Our Ref: LU/165/19/HH
Your Ref:

Town & Country Planning Act 1990 (as amended)
Town & Country Planning (Development Management Procedure) (England) Order 2015
Application for Planning Permission for Works or Extension to a Dwelling

Development Rear Ground floor extension and porch to front
Location 70 Linnet Close Littlehampton

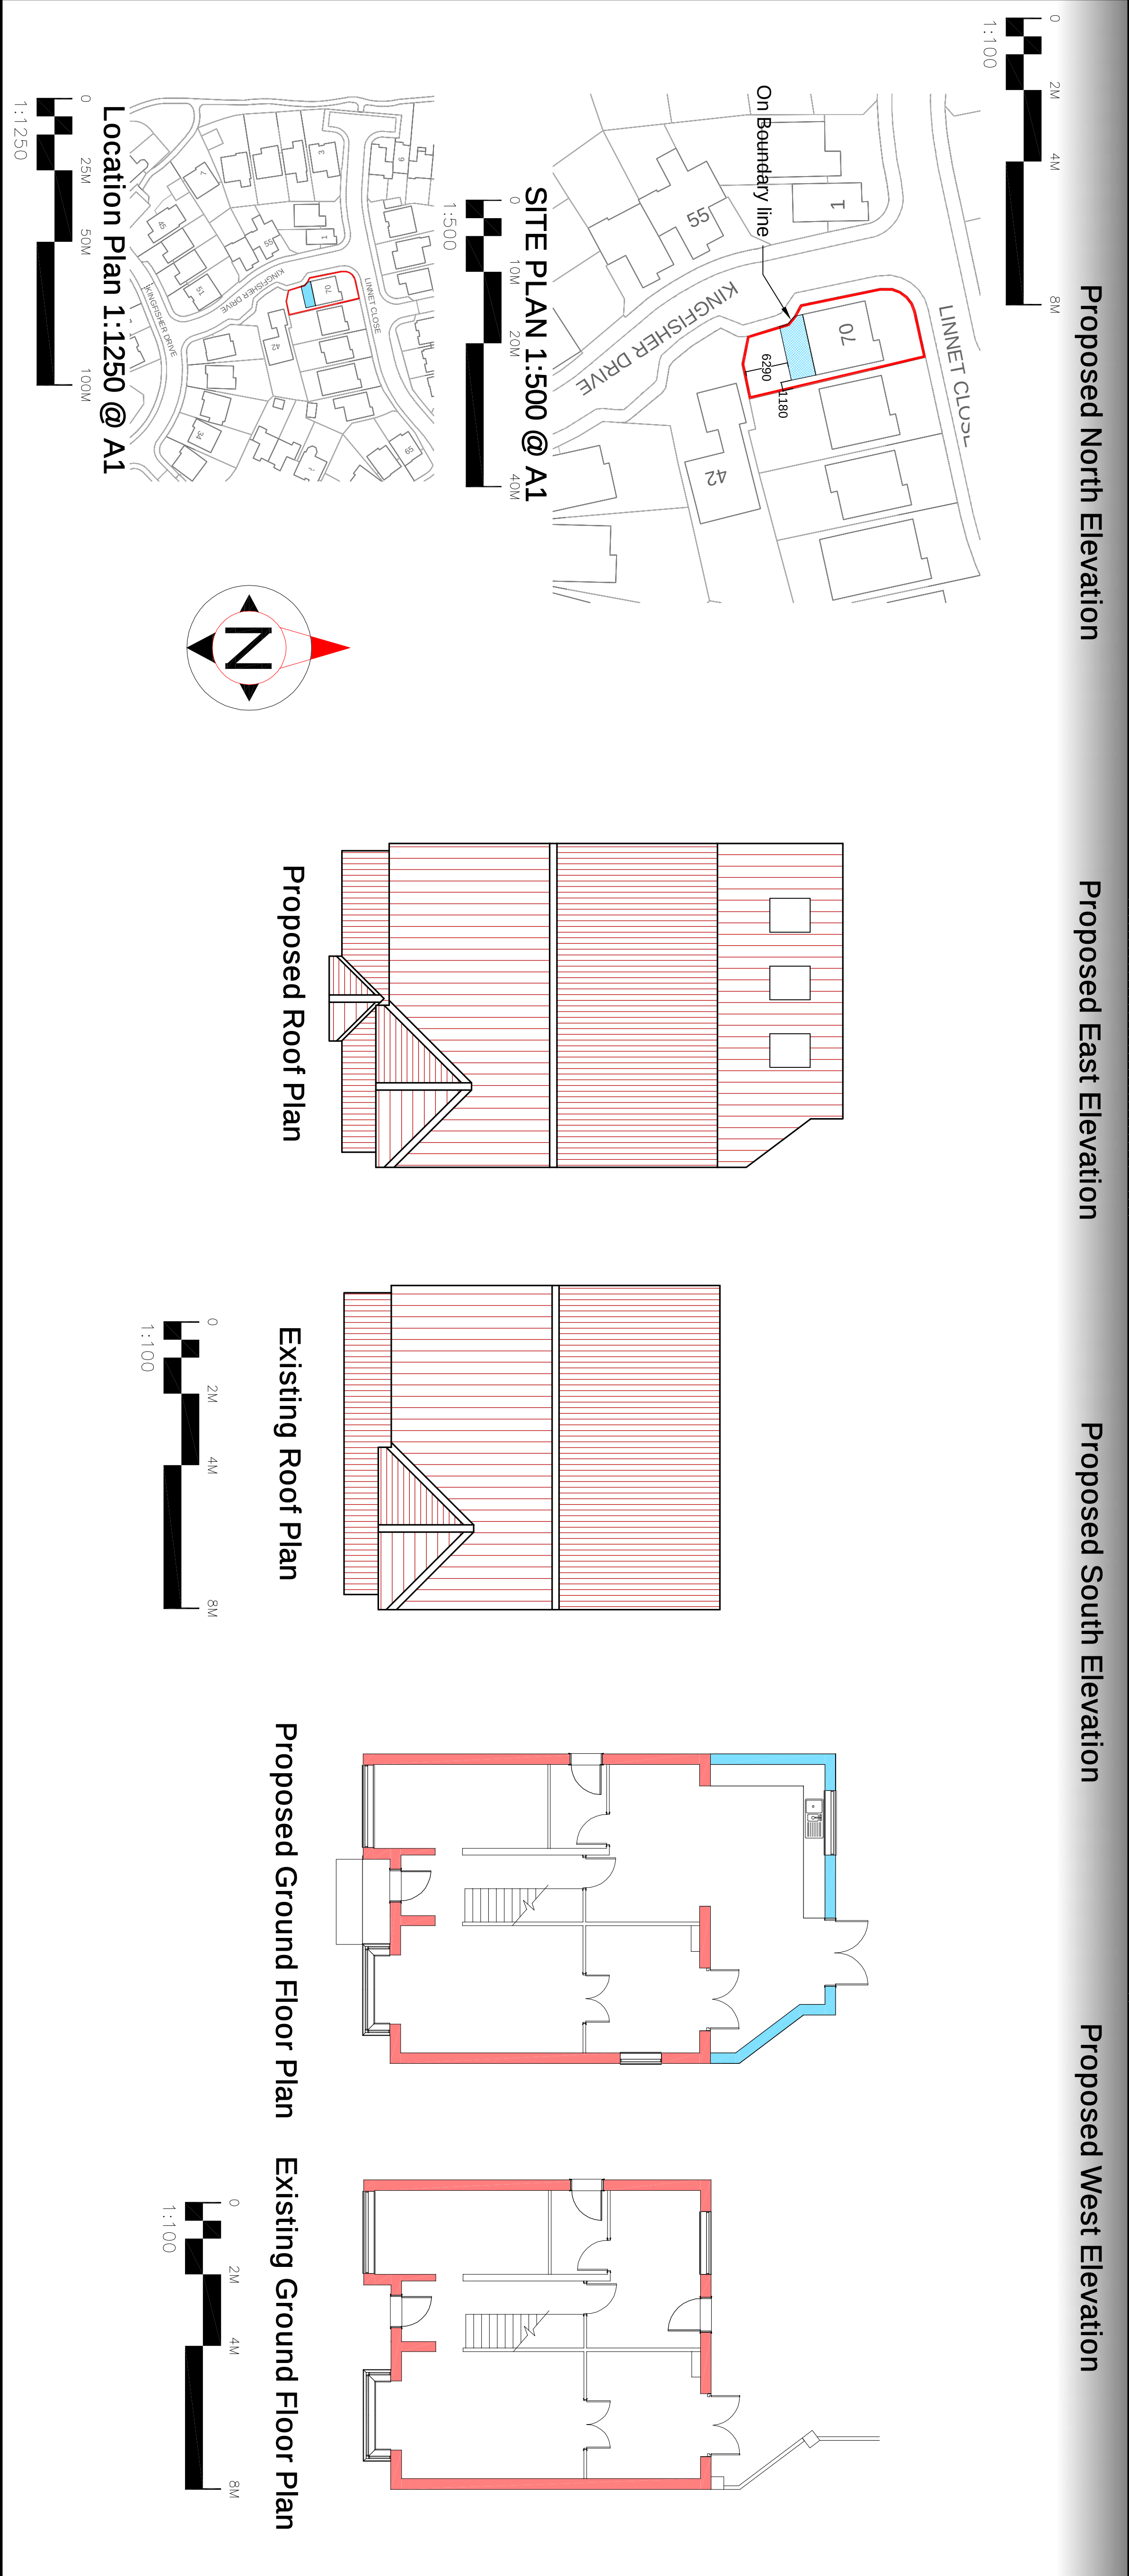
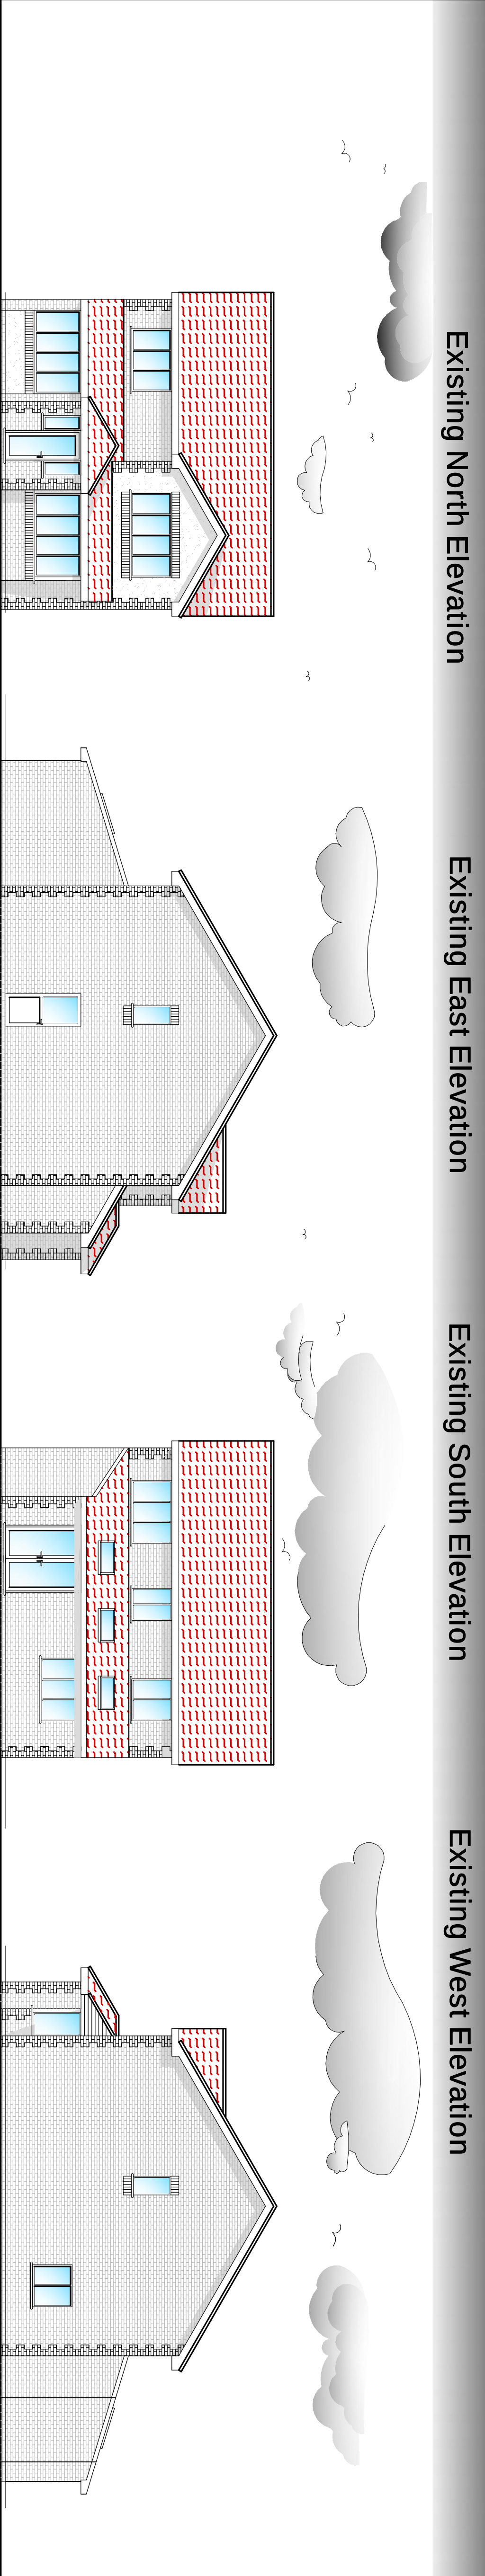
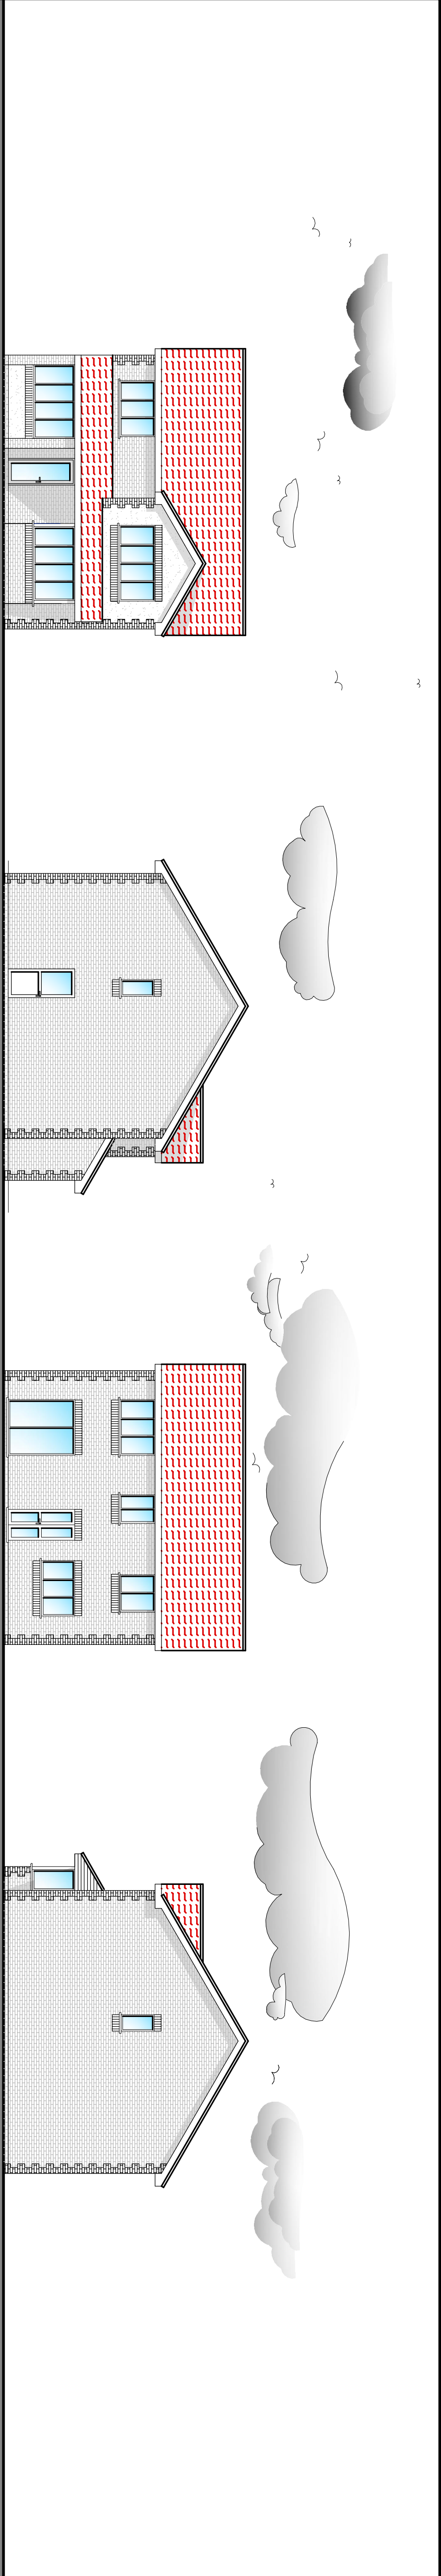
Please submit 1 electronic or 3 paper copies of a block/site plan which includes dimensions from the proposed extensions to the site boundaries.
